Application ID: S6/2013/1886/FP - Miss K Phillips Application Owner: Welwyn & Hatfield Borough Council (Development Management Officer)

Location: 5 Orchard Close

Description: Erection of two storey side and rear extension, loft conversion and front bay windows
Comment Added:

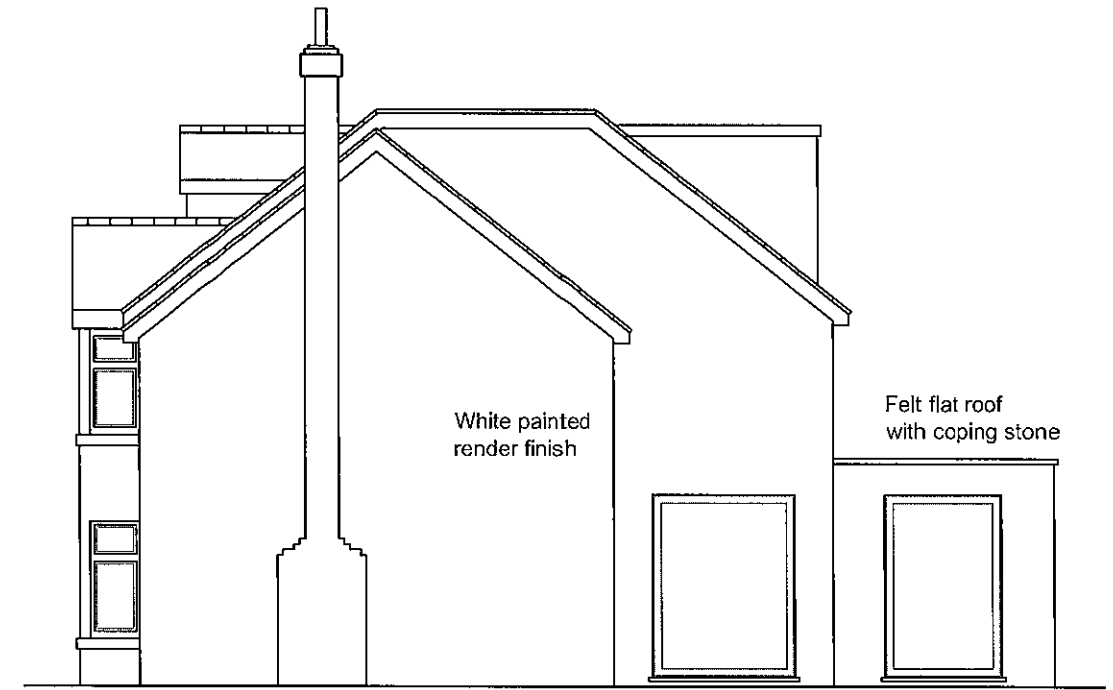
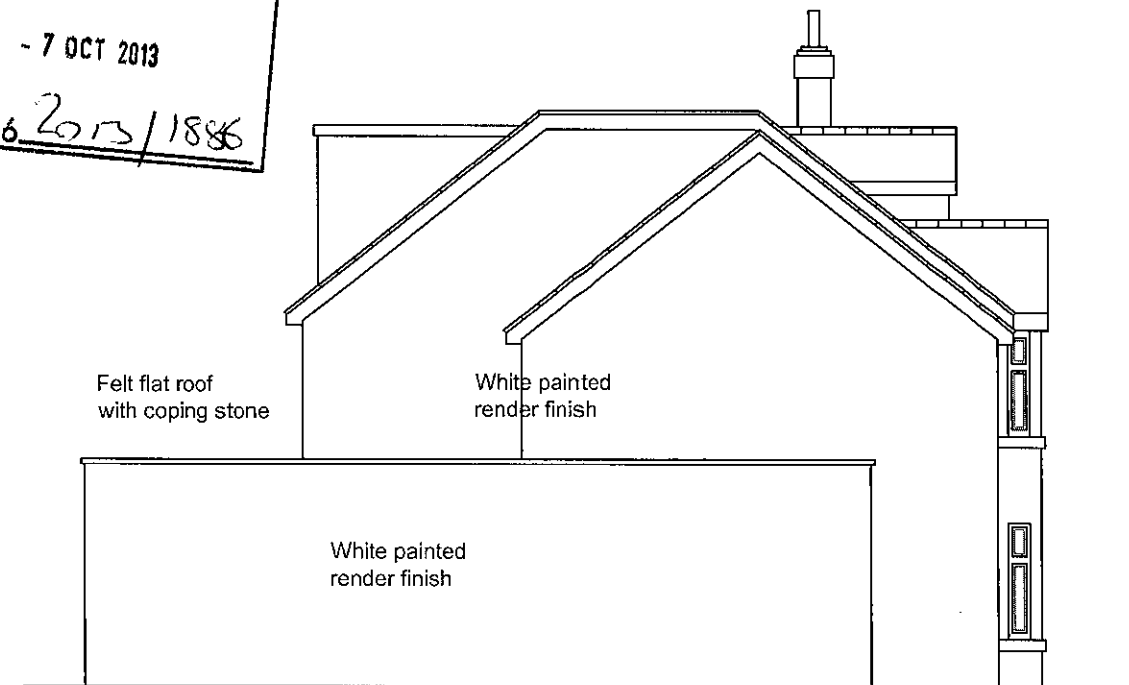
Comment: The PC feel this is an overdevelopment of the site and will not be in keeping with the rest of the houses within a confined Close and could easily cause overlooking of both adjacent properties.
